Our Ref: A/11/20/HH

**Town & Country Planning Act 1990 (as amended)
Town & Country Planning (Development Management Procedure) (England) Order 2015
Application for Planning Permission for Works or Extension to a Dwelling**

Development Loft Conversion and Balcony
Location Thatched Corner Ham Manor Way Angmering

| REVISIONS                                                                                                                                               |                |
|---------------------------------------------------------------------------------------------------------------------------------------------------------|----------------|
| DRAWING<br>PROPOSED<br>DATE: DECEMBER 2019<br>DRAWN: T. Murray                                                                                          | SCALE<br>1/100 |

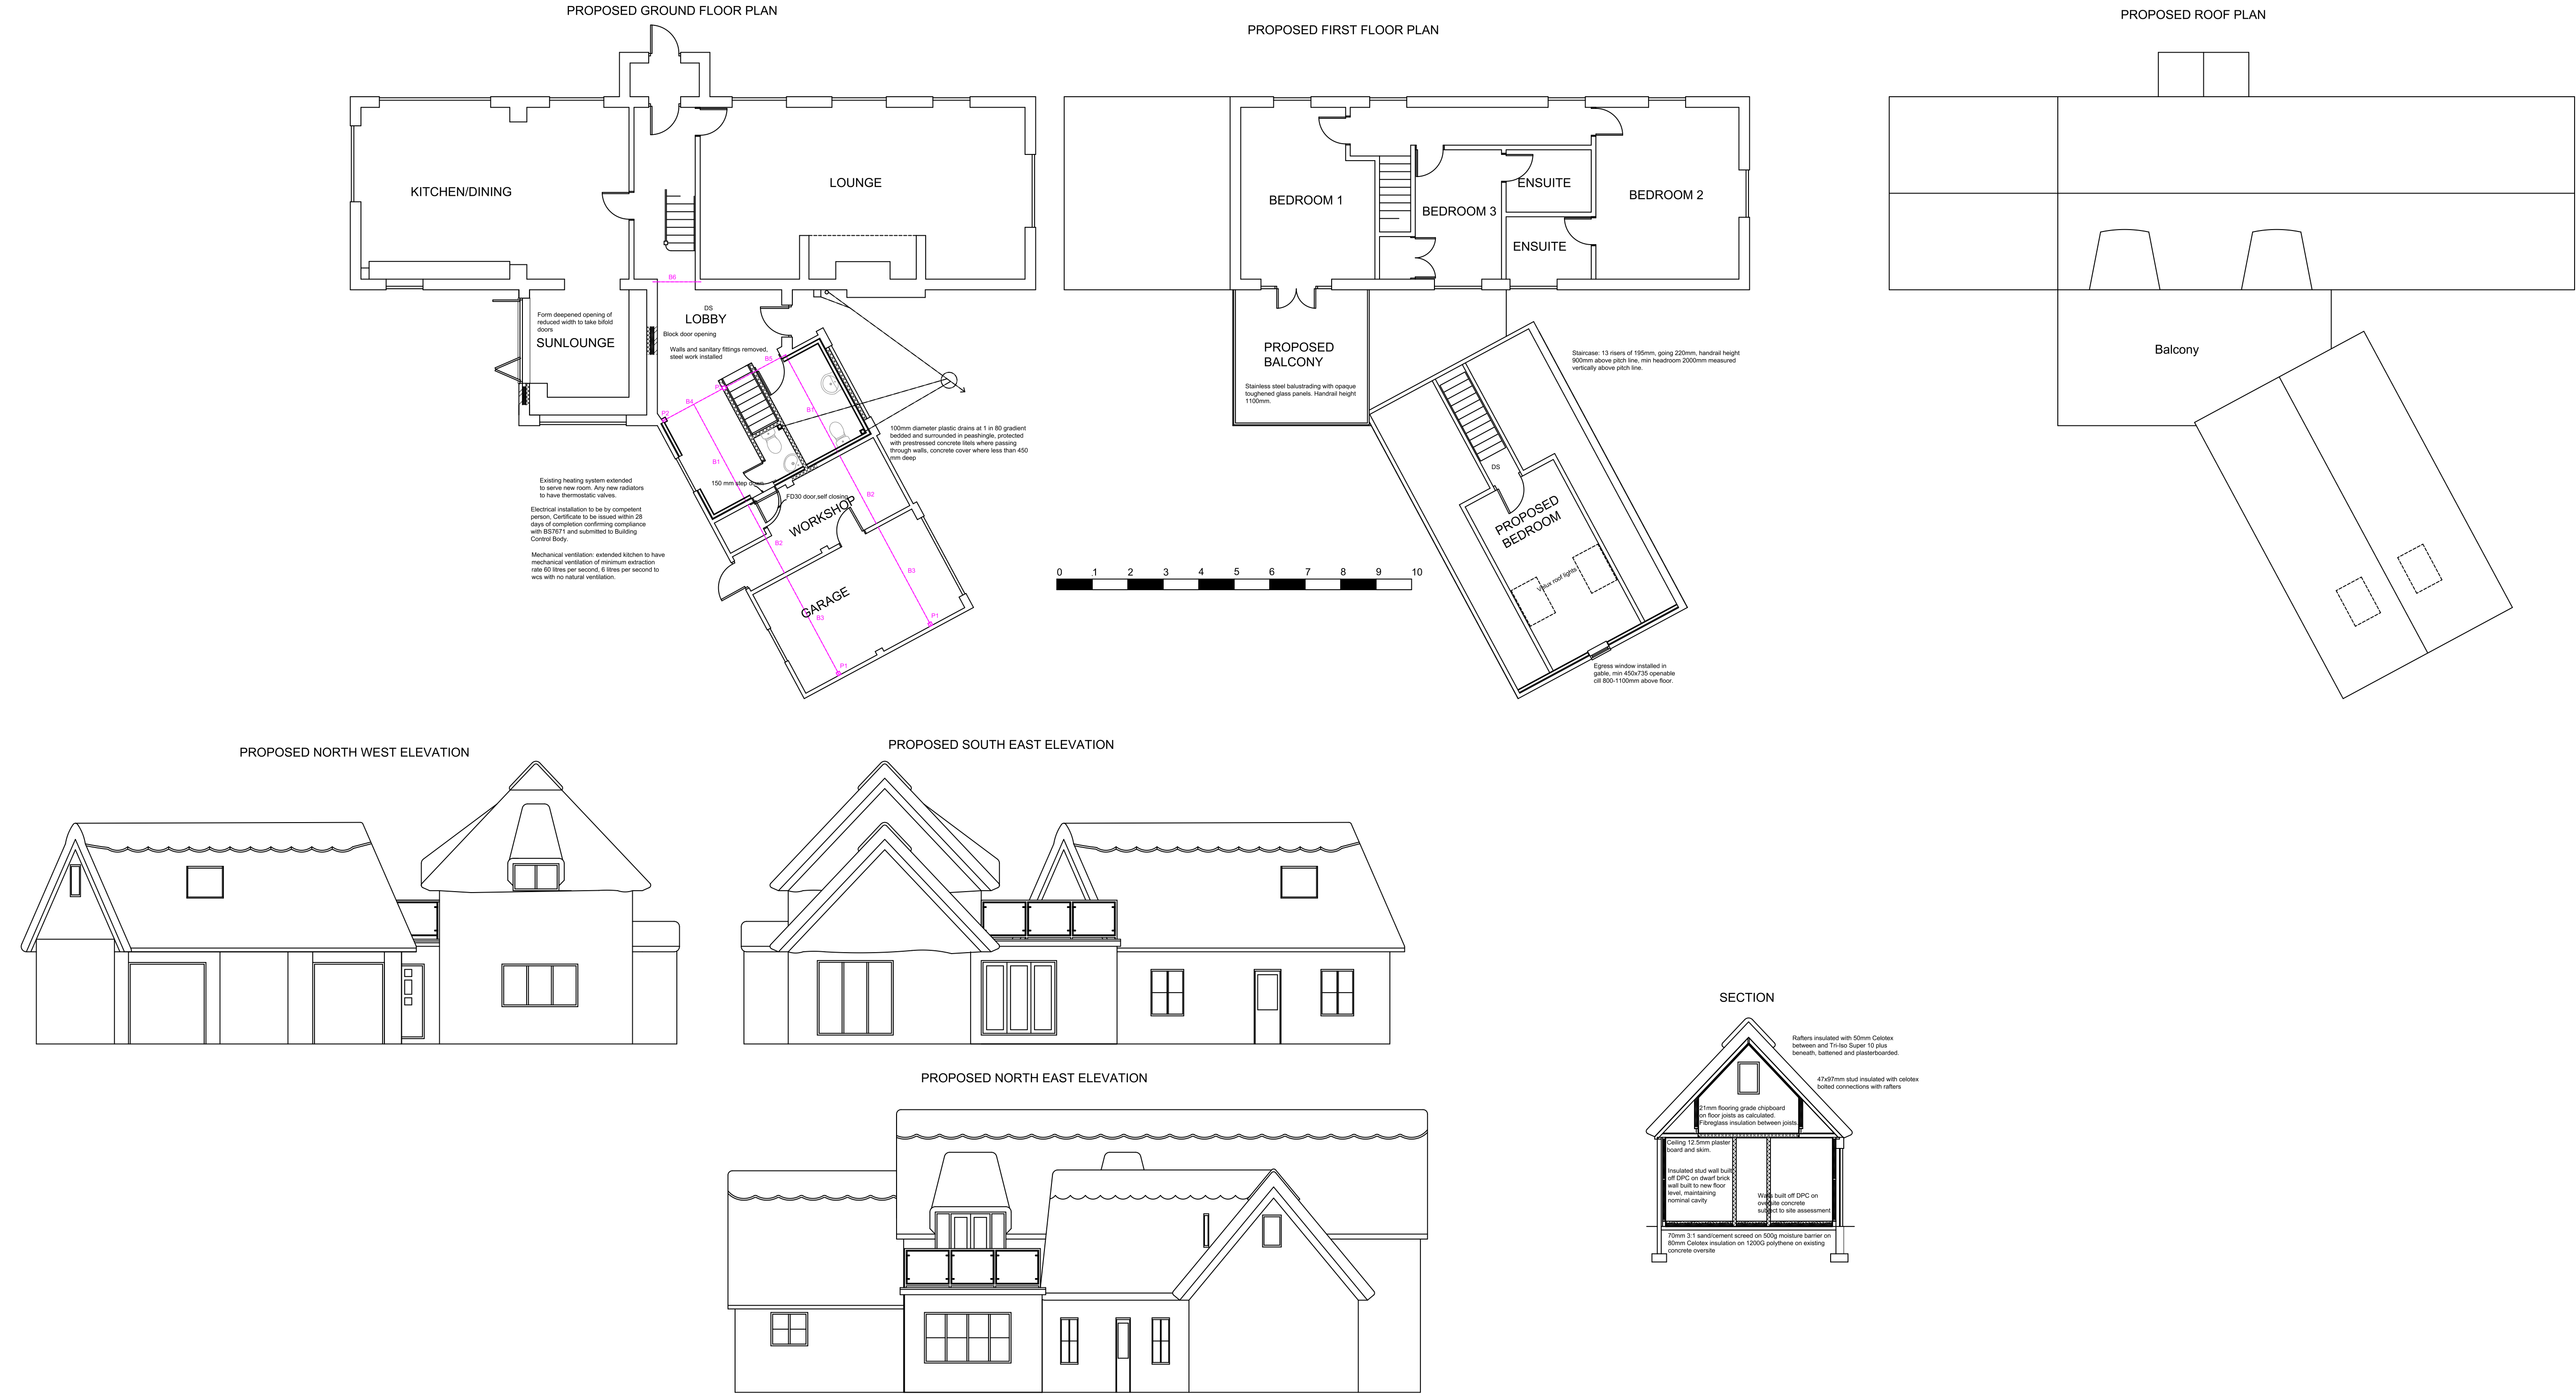
Scale: The scale is currently unclear as it overlaps other writing on the page. A scale bar is also required on all plans.

Elevation: Please provide the other side elevation to show the balcony.

Confirmation Required: Please confirm whether the existing floorspace is habitable as it currently looks as if you are proposing a part conversion to incorporate into the main dwelling.

Room Labels: You are required to include room labels on all floor plans.
